Project Ref: TE/LB/24\_766

**Re: Planning reference H12-0930-24: Sunindale, Lutton, Marriots Gate, Spalding PE12 9HN**

I have reviewed the changes to the proposed site layout with respect a residential development of the above referenced site. There are no anticipated impacts from an ecological perspective as a result of the layout changes. Although the footprint of the new dwelling will be within closer proximity to the southern boundary, the Reasonable Avoidance Measures outlined within the Preliminary Ecological Appraisal report (Torc Ecology Ltd, 2024) are fit for purpose and will ensure the south boundary vegetation, and any wildlife it may support, is protected during the construction phase.

Proposed Site Plan 1:500

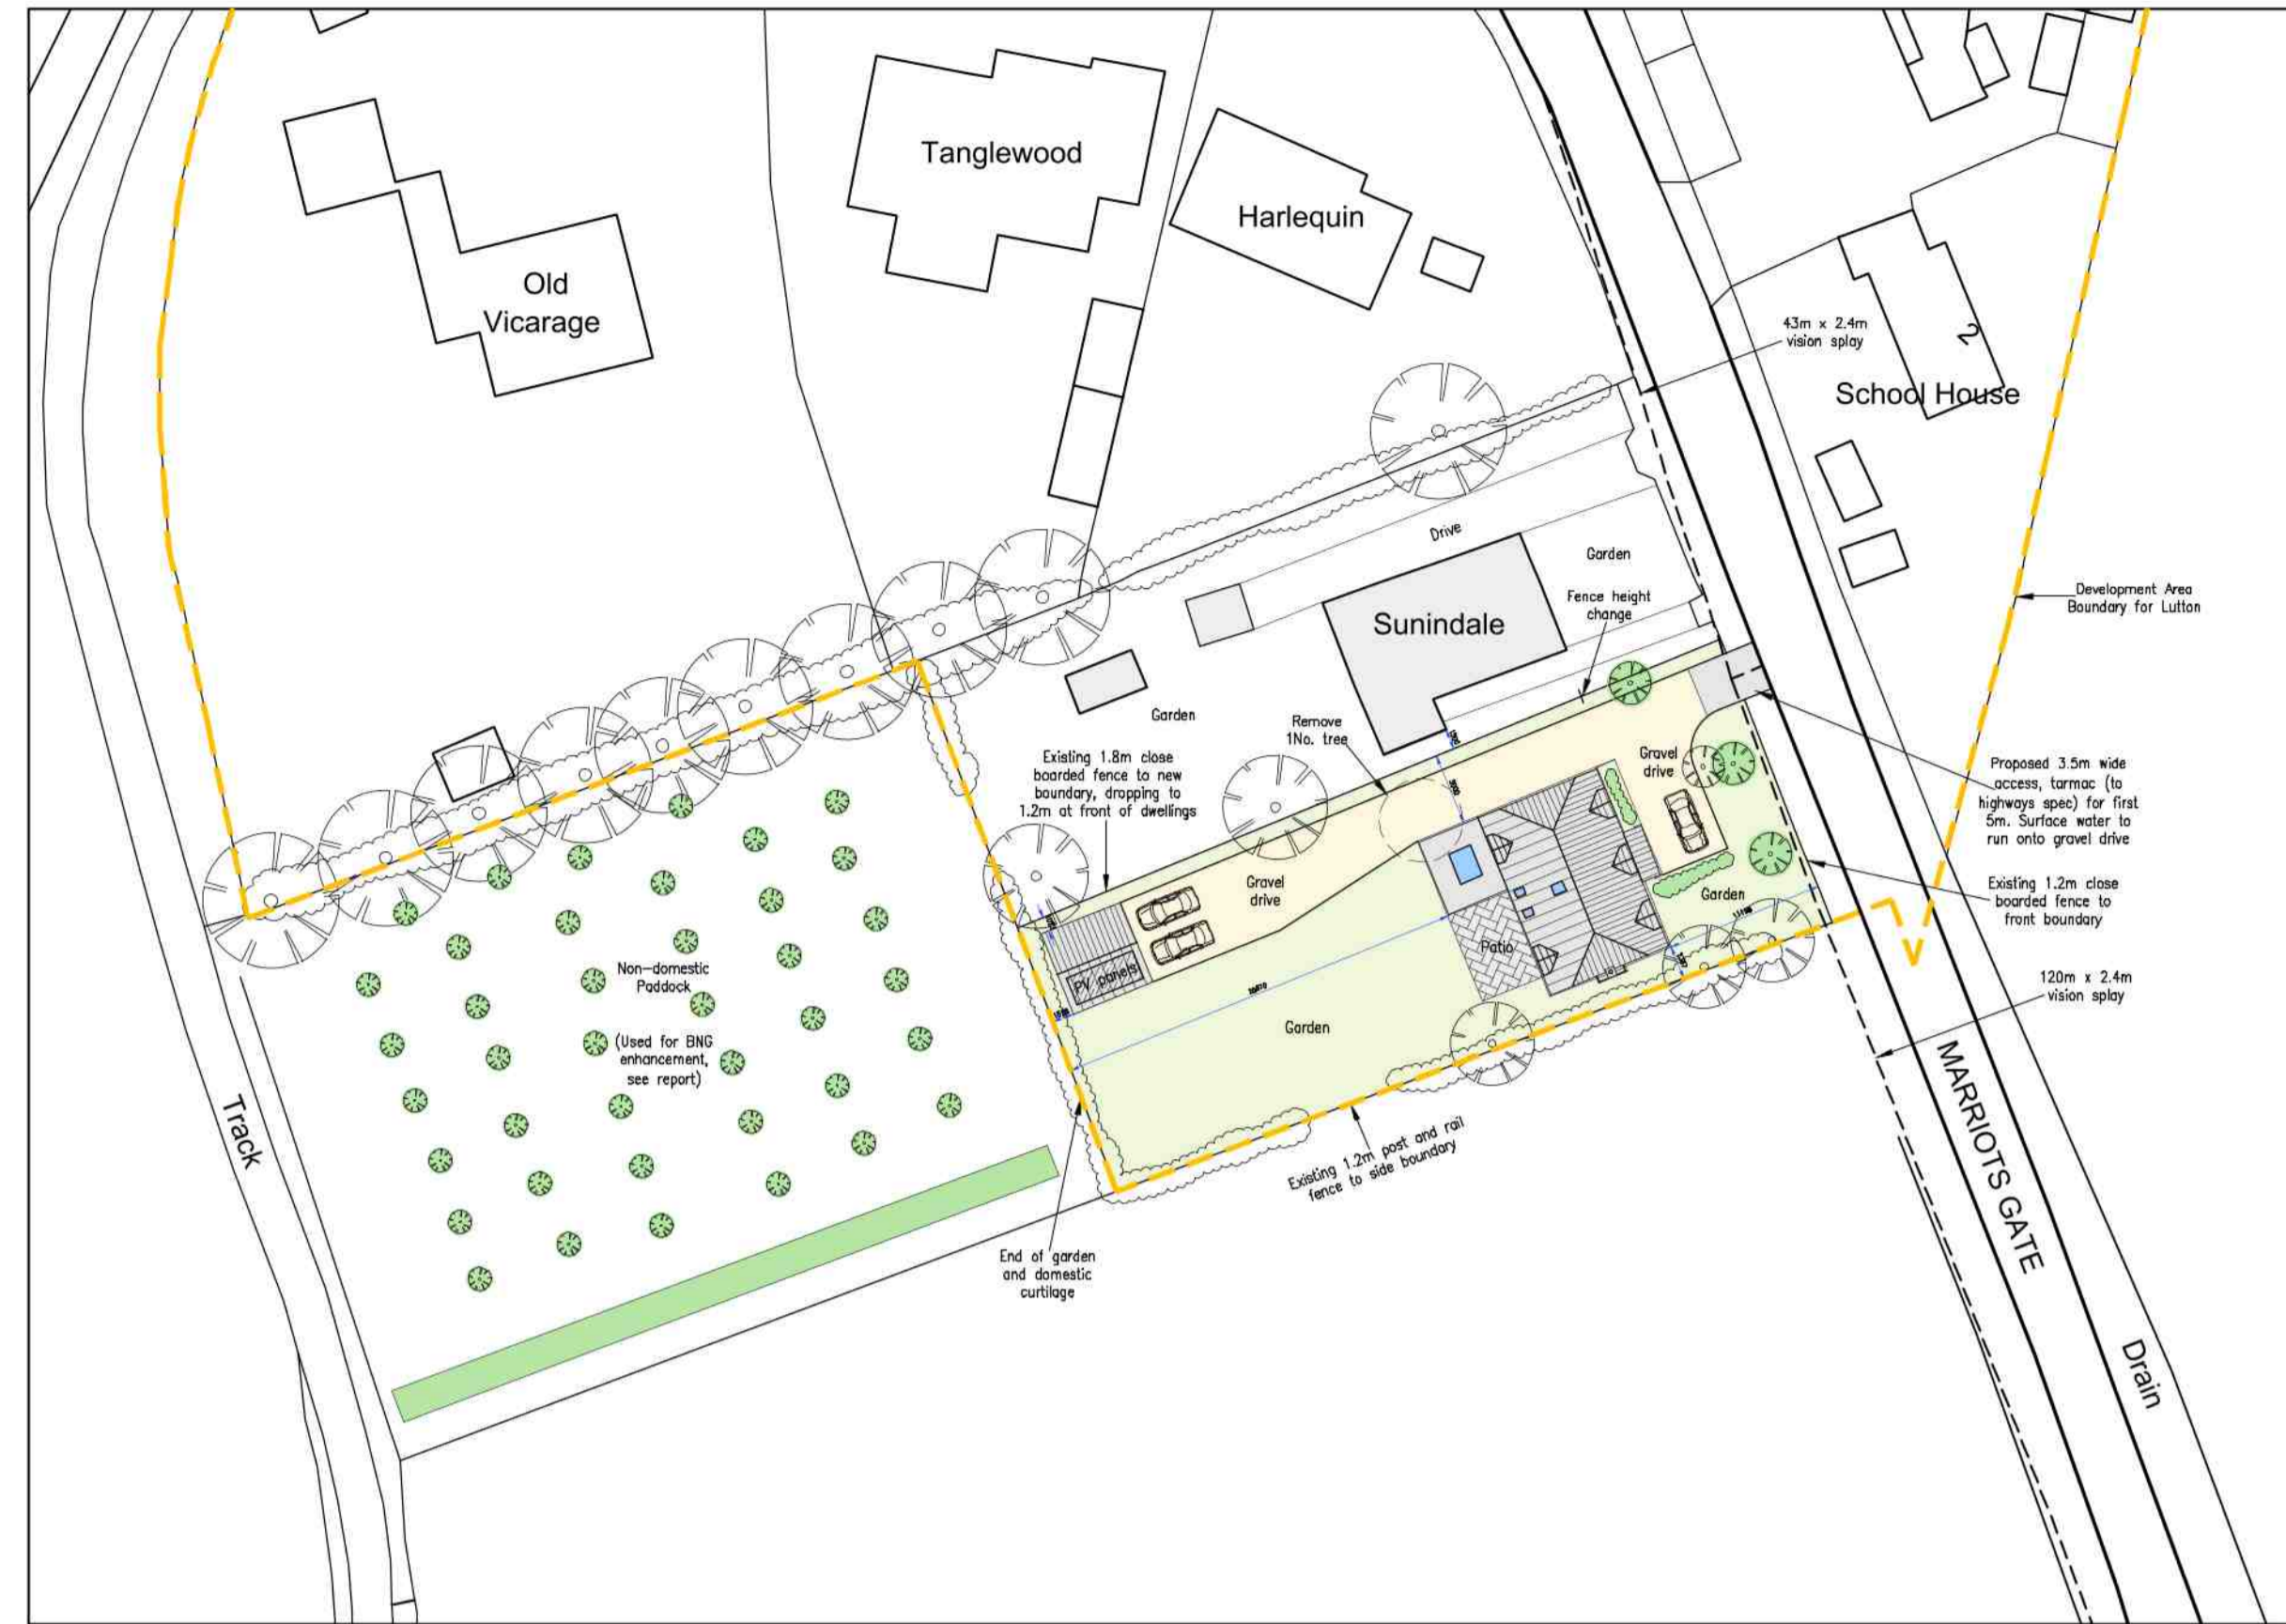
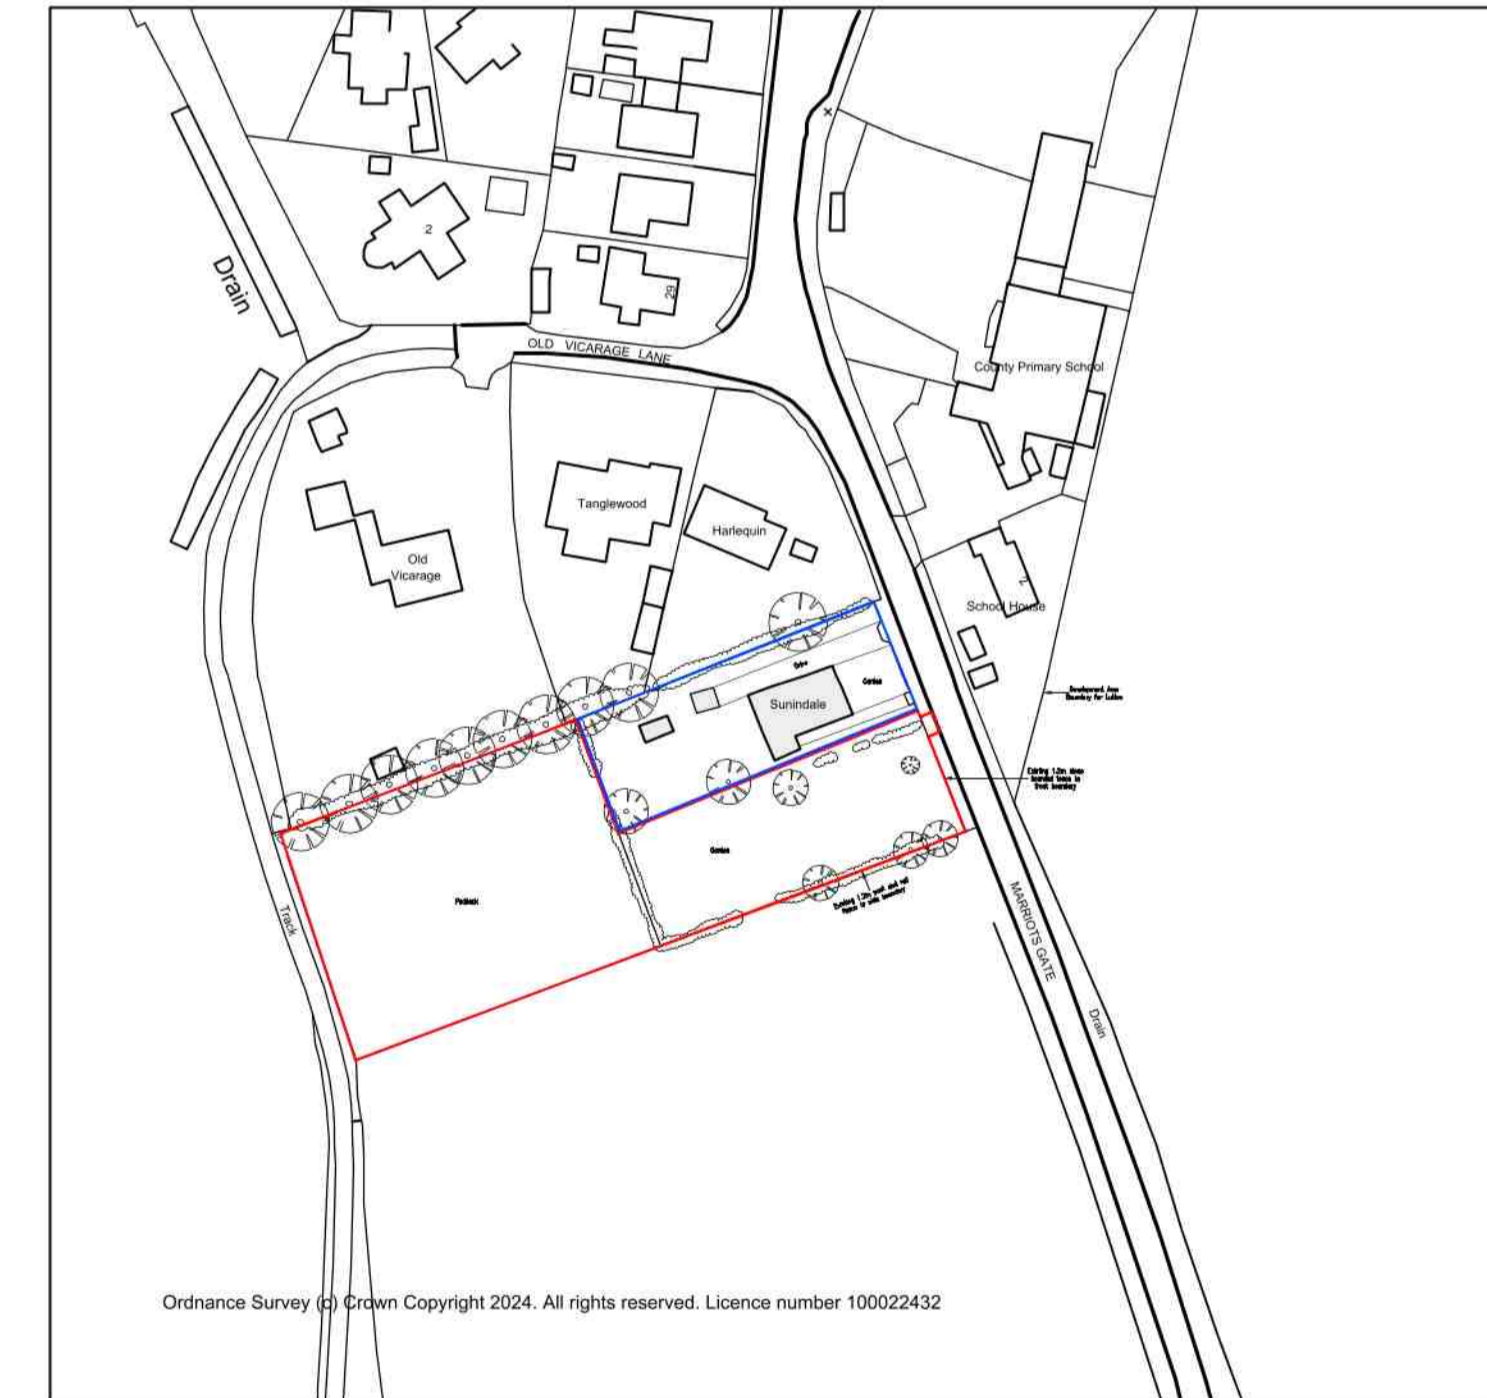
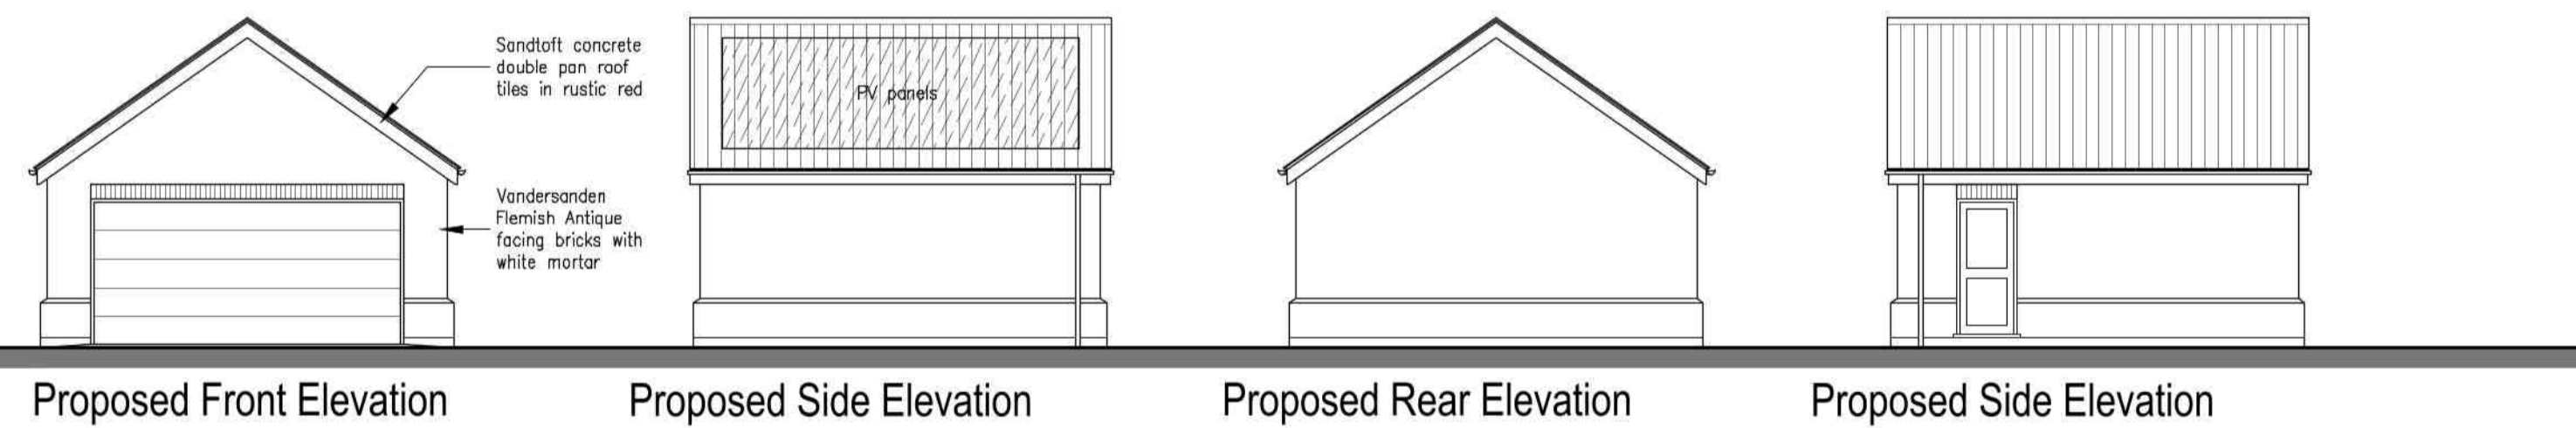
I have reviewed the revised layout with respect the biodiversity net gain calculation and there are no anticipated changes required in this respect.
